PLANNING AND INFRASTRUCTURE

30 July 2024

**Re: State Significant Development Application Number SSD-66777221
2-8 Lanceley Place and 14 Campbell Street, Artarmon.**

2.1.2 Fire Brigade crossover

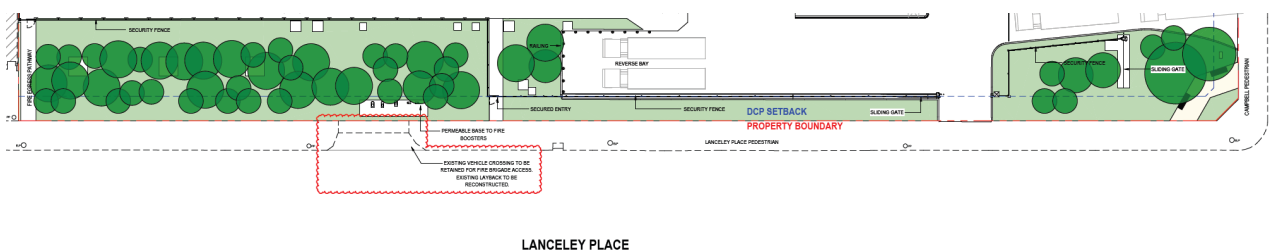
The plans include a secondary vehicle access point via Lanceley Place, towards the corner with Campbell Street (and that main vehicle access point). It is not clear why all access cannot be provided from Campbell St. Concern is raised with the proximity of this second access point to the main access. Council requests further justification be provided or the plans be amended to remove the second access point; removing the additional access will provide further opportunities for improvements to the landscaping.
